KITITITAS COUNTY

MEMORANDUM

TO: Community Development Services
FROM: Public Works Planning Review Team
DATE: April 20, 2021
SUBJECT: SE-21-00006 Nunnally

SEPA Application Comments

DRAWING NO.	C1.1
PROJECT NO.	20.010
DATE:	11/23/20
SHEET NO.	2 OF 10

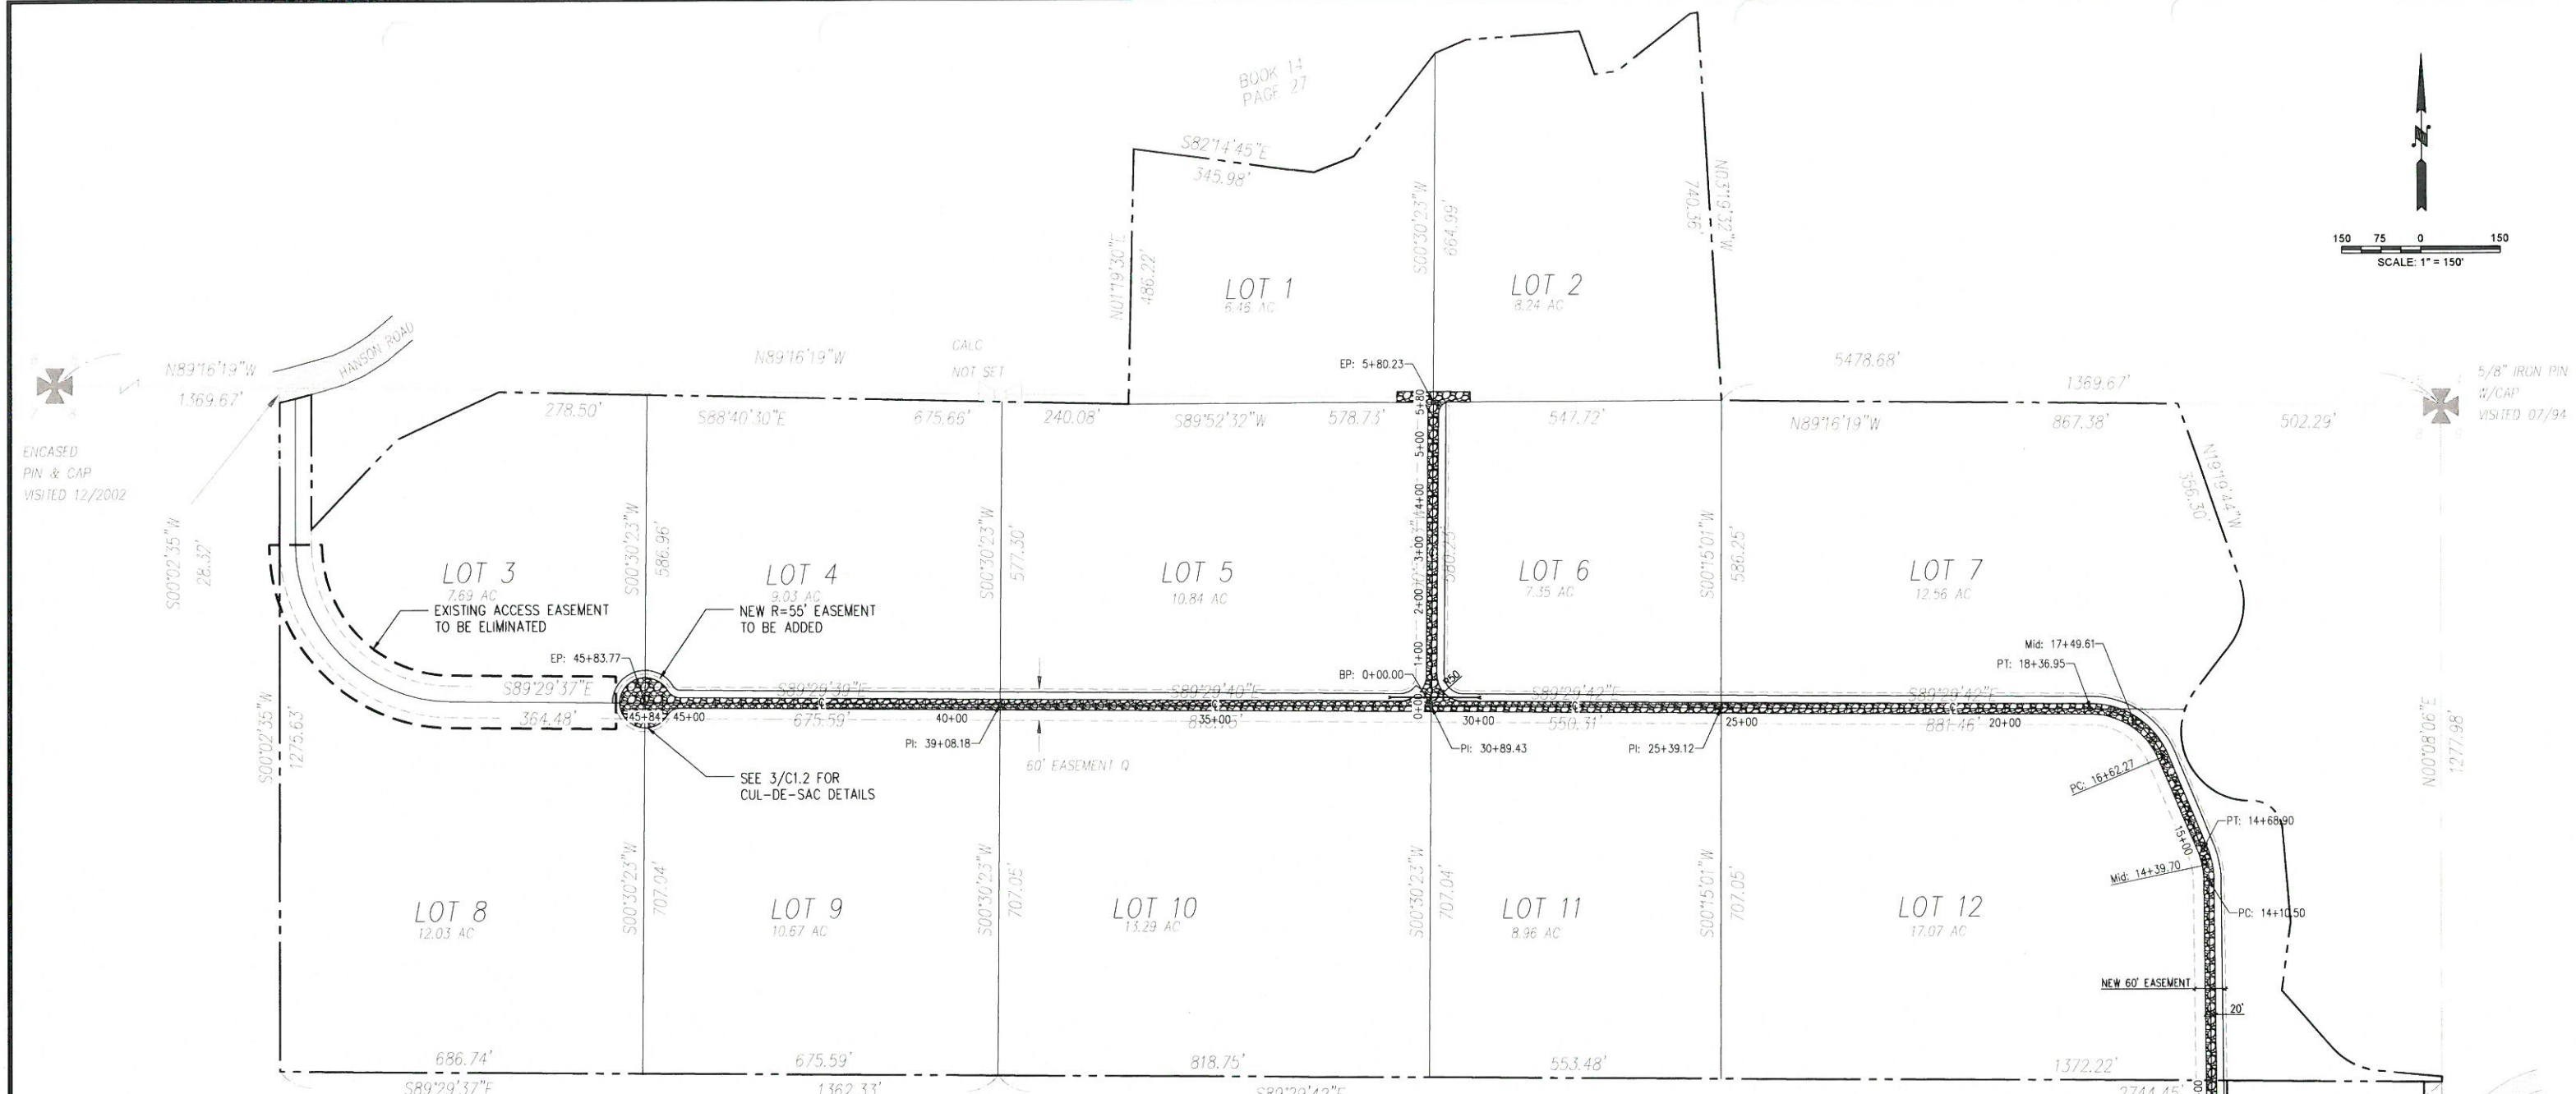
- The existing segregation of land provides access from Hanson Rd. There is no current access provided from the proposed Strande Rd. location. Please provide proof of legal access for the Strande Rd. connection.

4 PROPOSED ROAD SECTION
1" = 5'

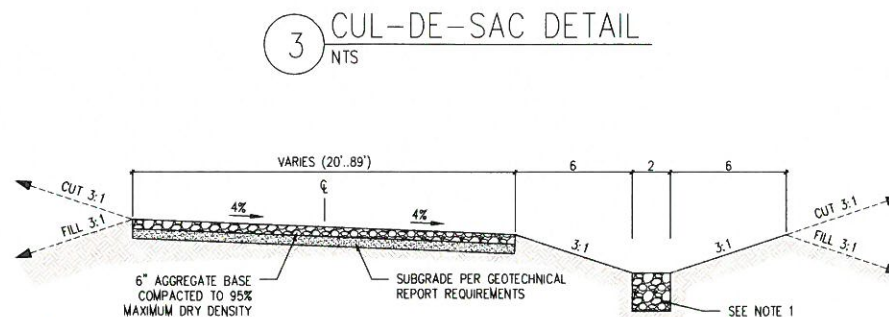
- The proposed roadway shall meet or exceed current Kittitas County Road and Bridge Standards. Kittitas County Public Works will require a certification from a licensed engineer in the State of Washington for the private road.
